Date: 17 January 2025
Our ref: 497689
Your ref: **EN010128**

NSIP Reference: EN010128

**The Examining Authority's first written questions and requests for information (ExQ1).
Examining Authority's submission deadline: 17 January 2025**

Annex 1: Natural England’s response to the Examining Authority’s (ExA’s) first written questions reference ExQ1

Table indicating Lux Level

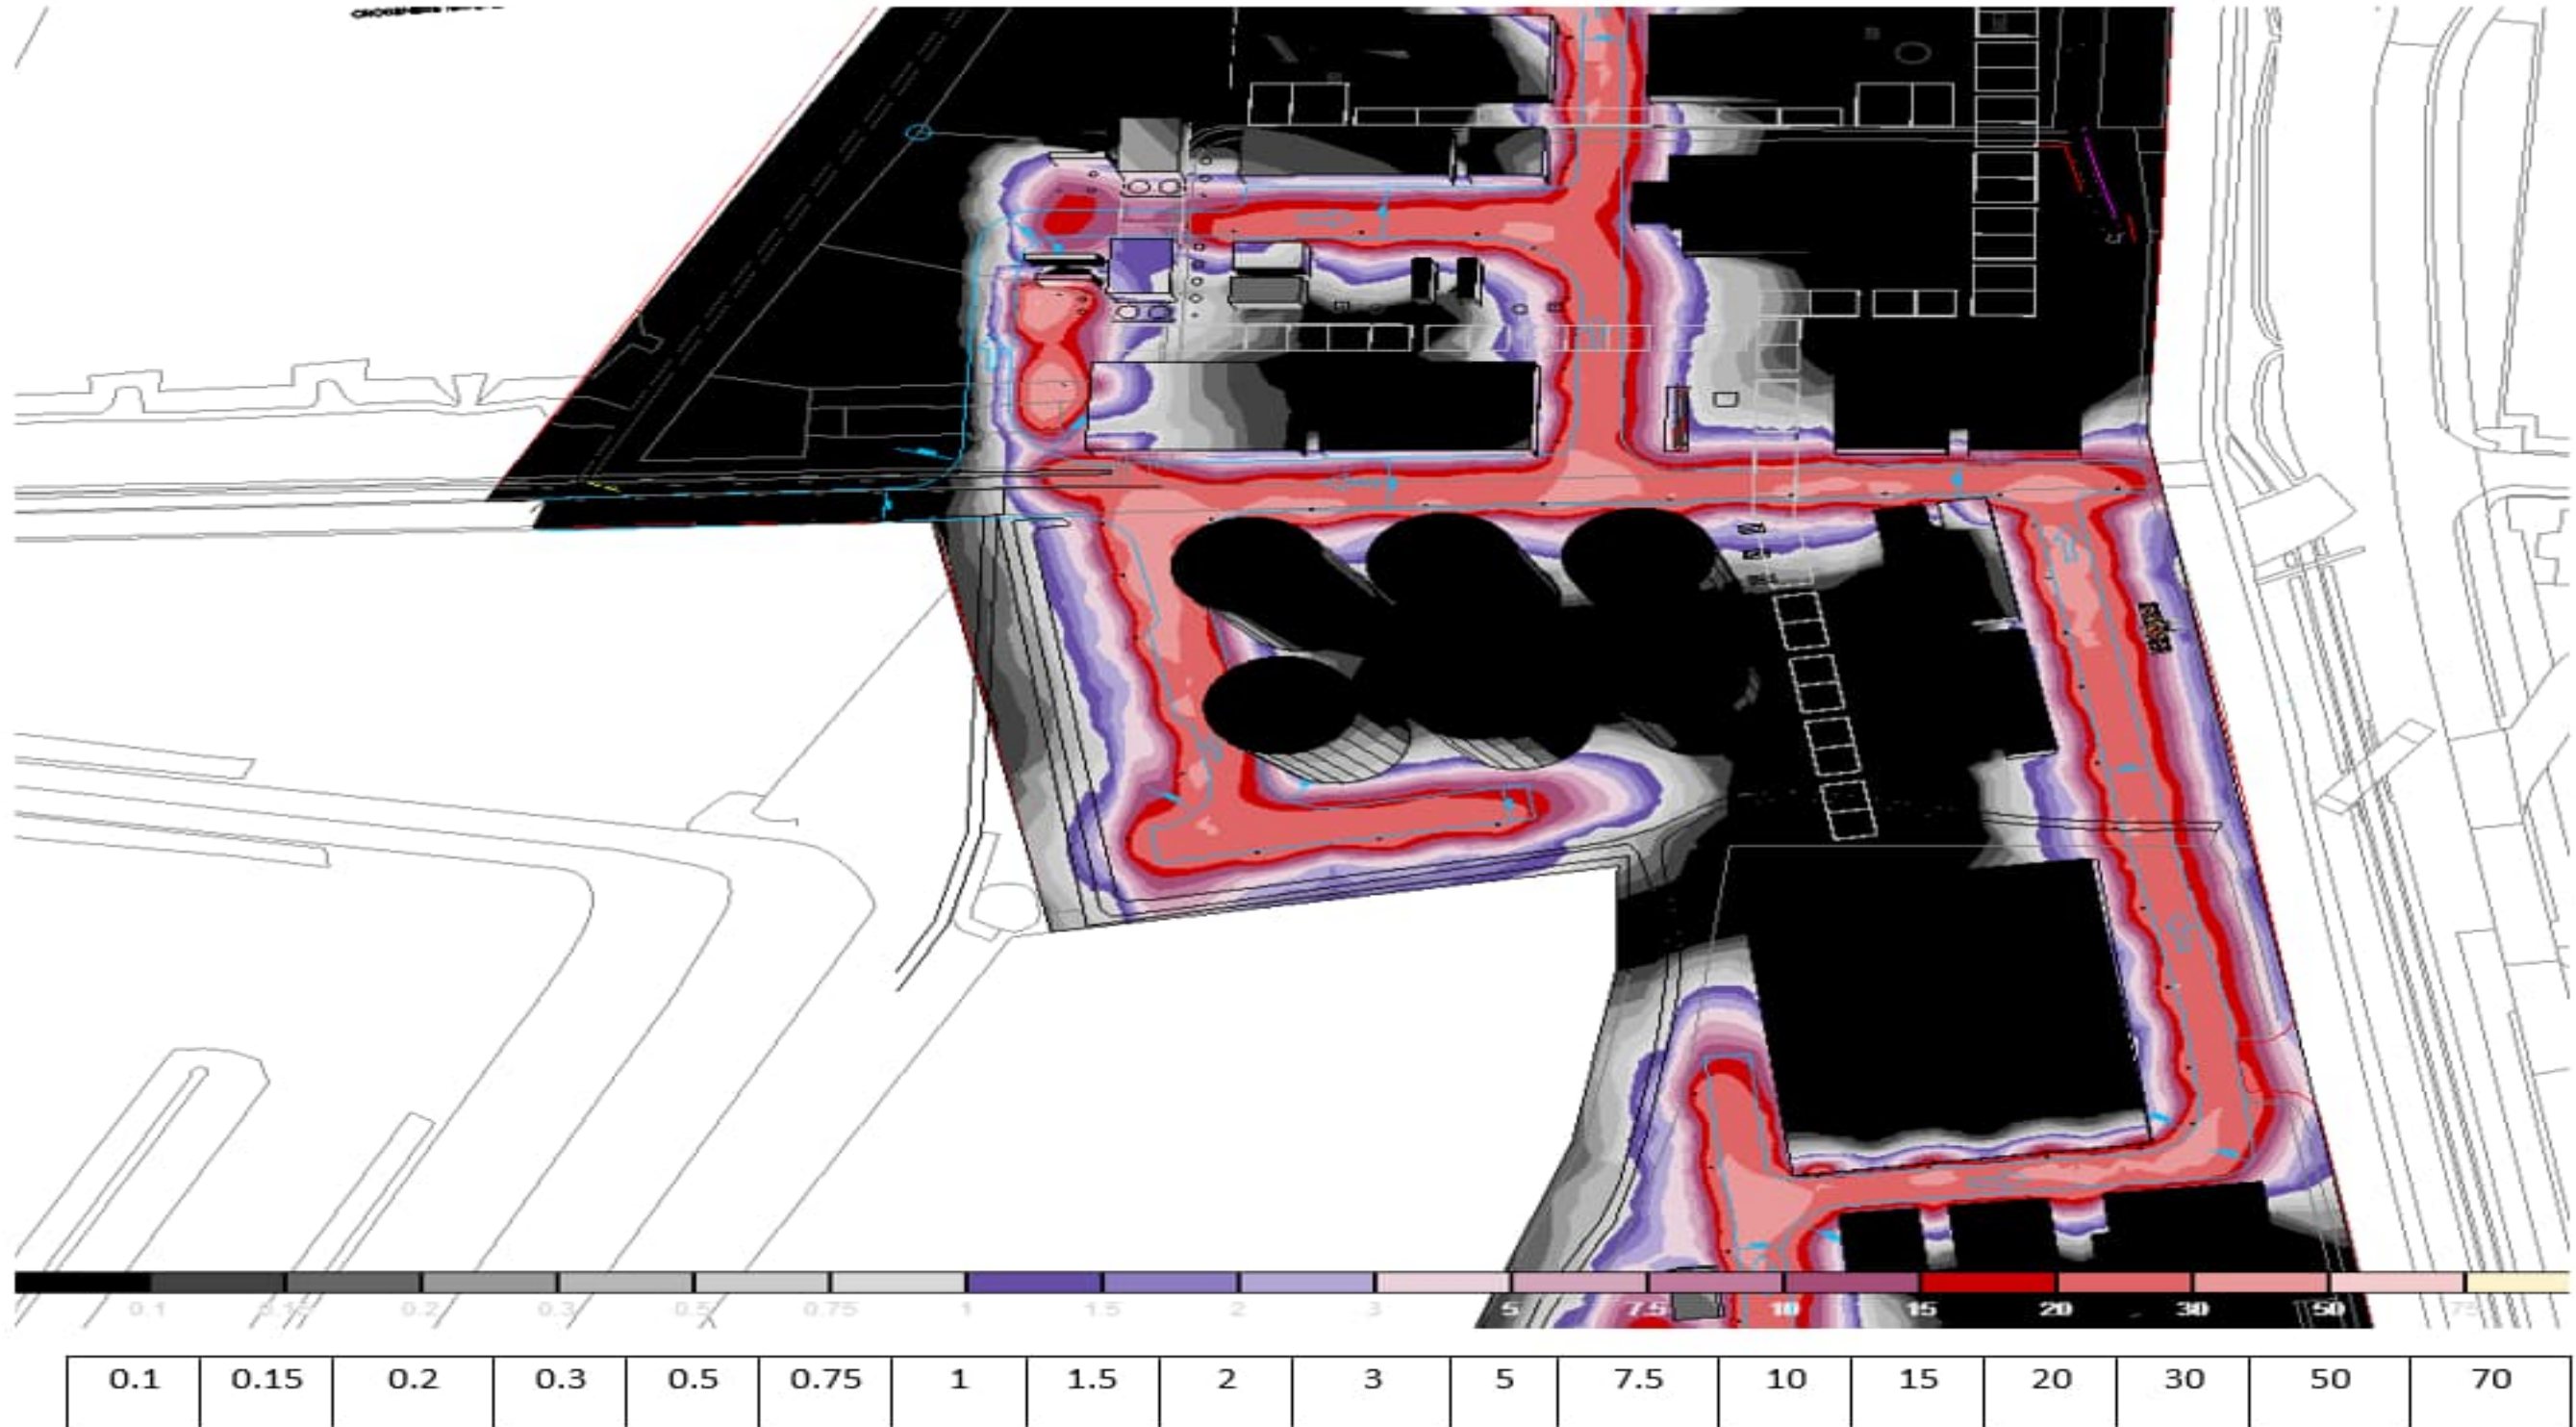
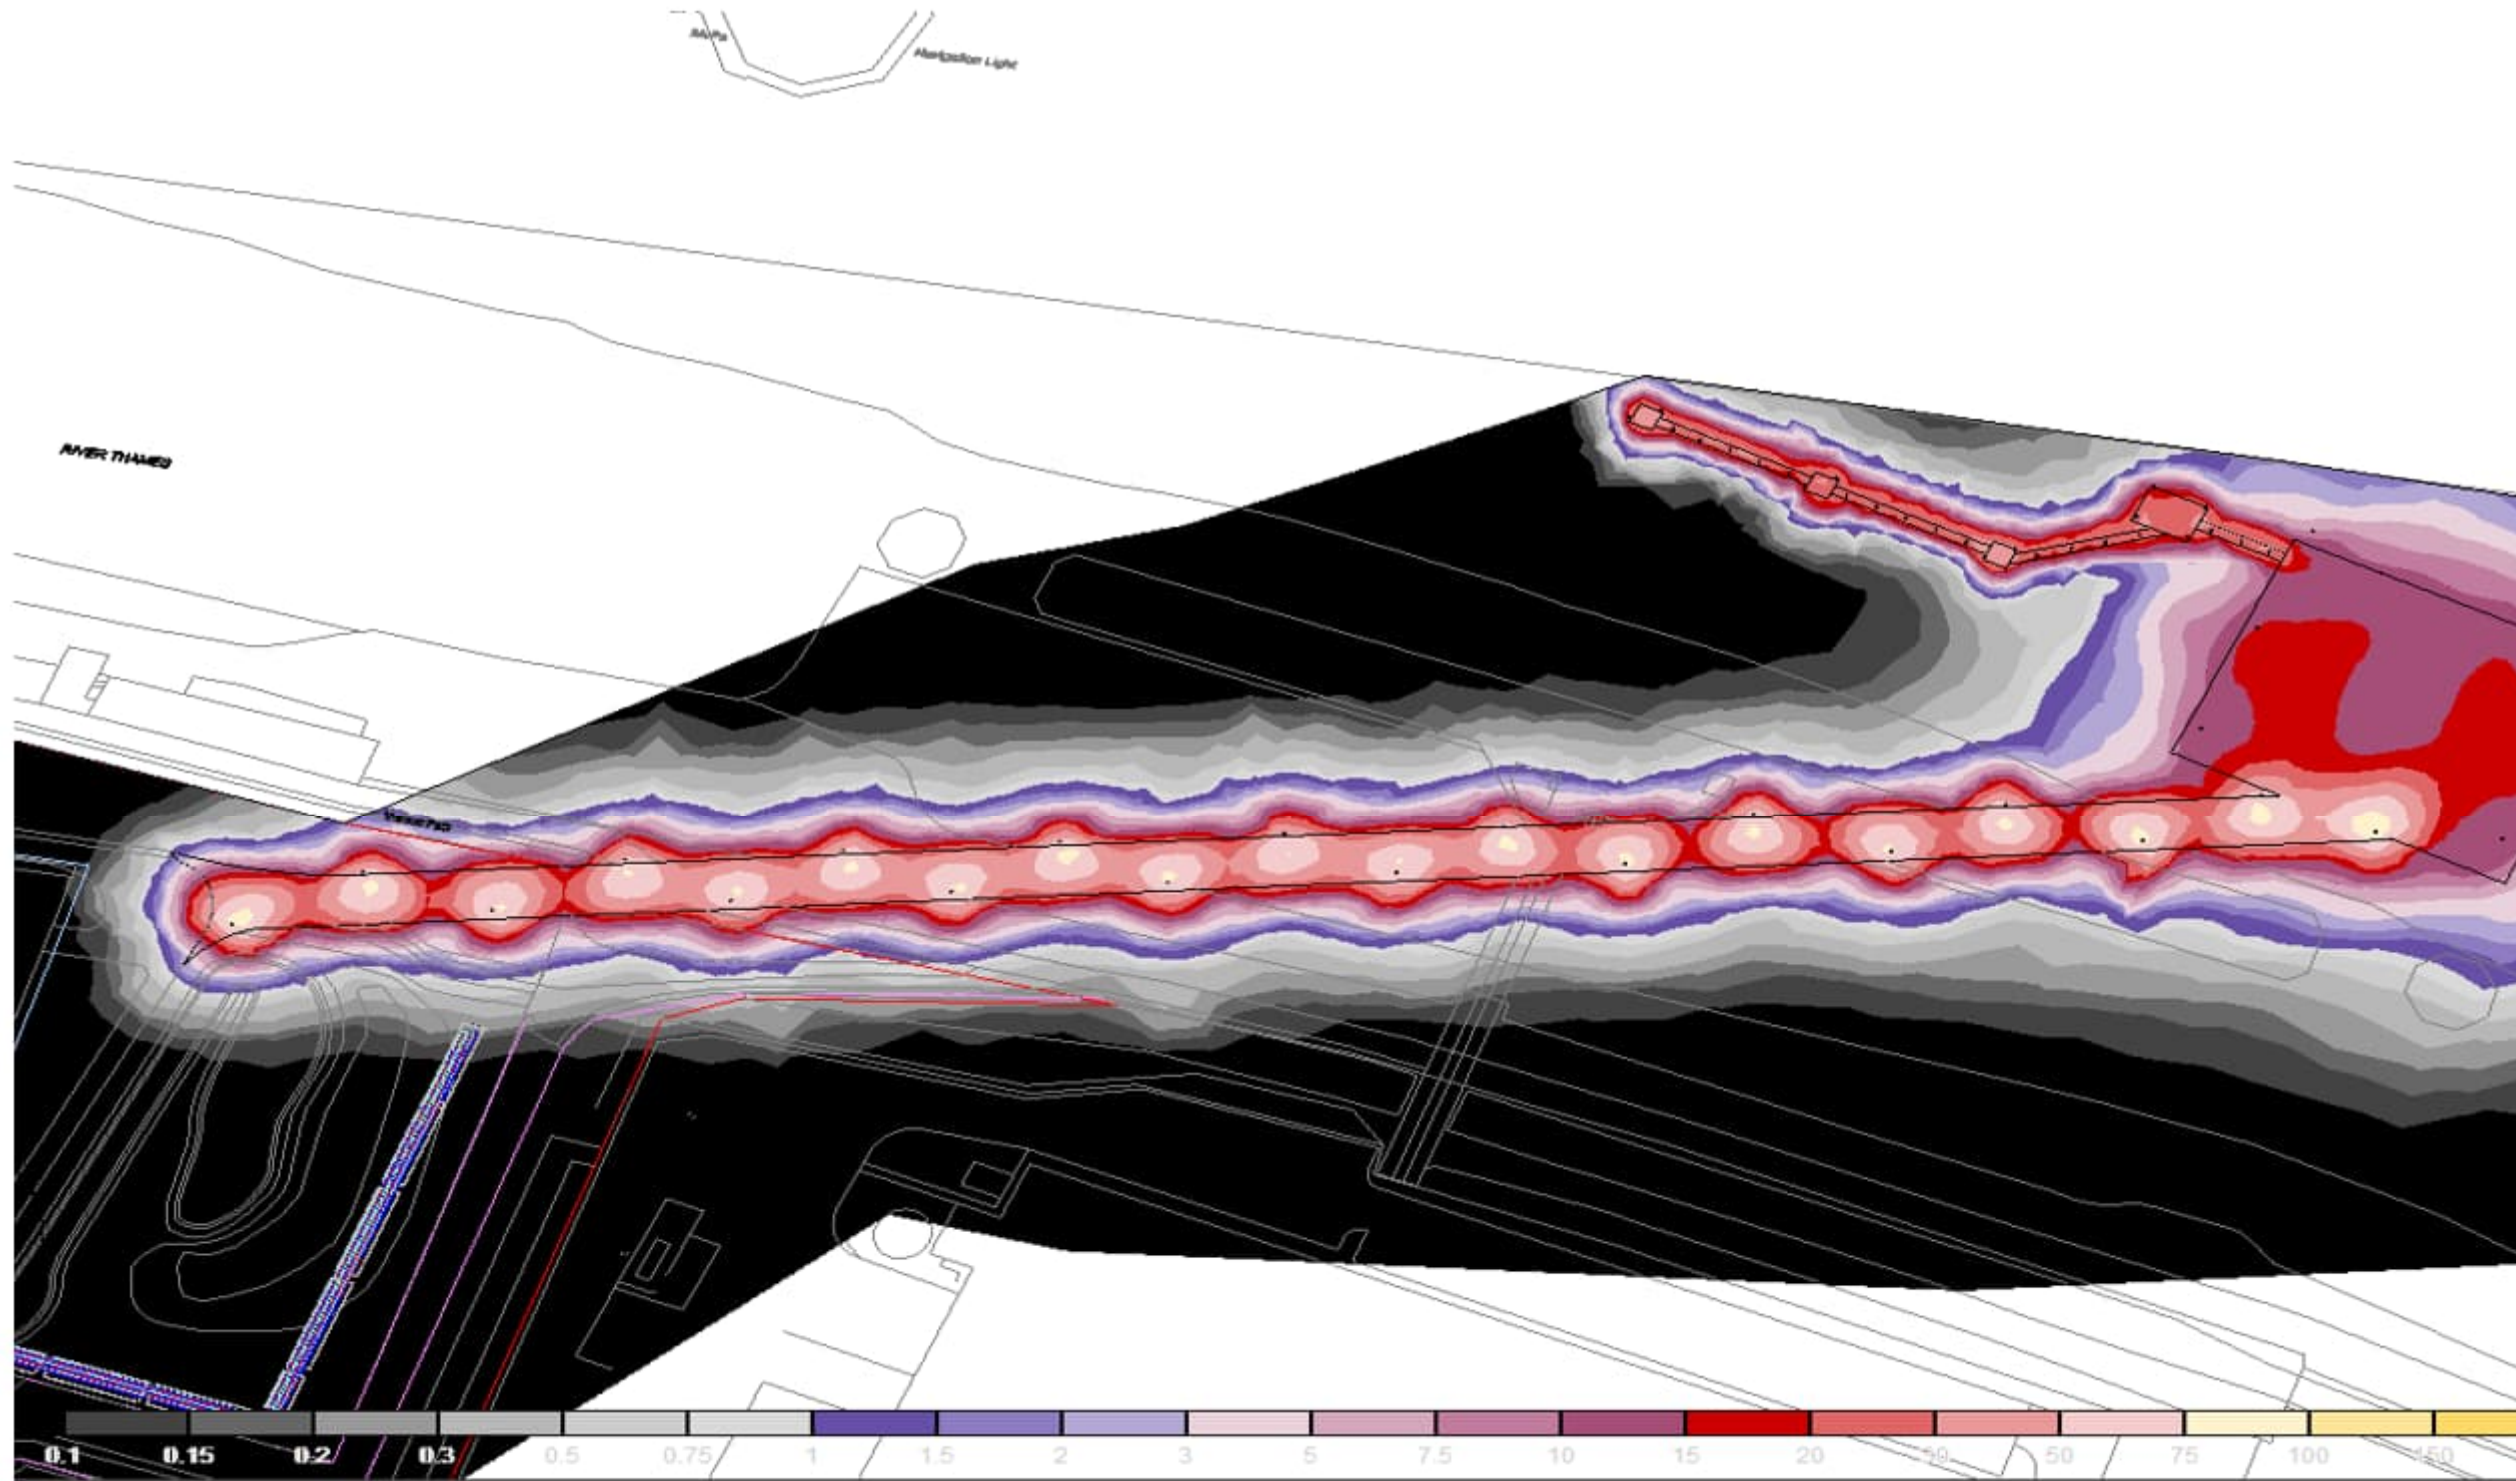
Q 1.3.1.5	The Applicant, NE and EA	<p><i>Would the lighting strategy required by Requirement (R) 11 in the dDCO be capable of mitigating effects of lighting on water voles? If so, please provide a full and detailed justification and if not, what alternative arrangements are proposed?</i></p> <p>The effects of lighting were not discussed as an impact to water voles within the Method Statement that Natural England reviewed. The lighting strategy [APP-123] does not specifically address potential impacts to water voles, or the mitigation of any impacts. Natural England has advised the Applicant that this section should be revised within the re-submitted version in order to ensure all the impacts of the proposed development are considered.</p>

ExQ1	Question to:	Question and Answer:
		<p>In principle, yes. We advise that we believe the wording of R 11 [REP1-002] as proposed, should be capable of ensuring any impacts to water voles are avoided or mitigated. The effectiveness of the requirement relies upon the detail and content of the lighting strategy [APP-123]. As discussed above, the lighting strategy [APP-123] does not currently specifically address potential impacts to water voles, or the mitigation of any impacts.</p> <p>Natural England would be pleased to be consulted on updates to the lighting strategy.</p>
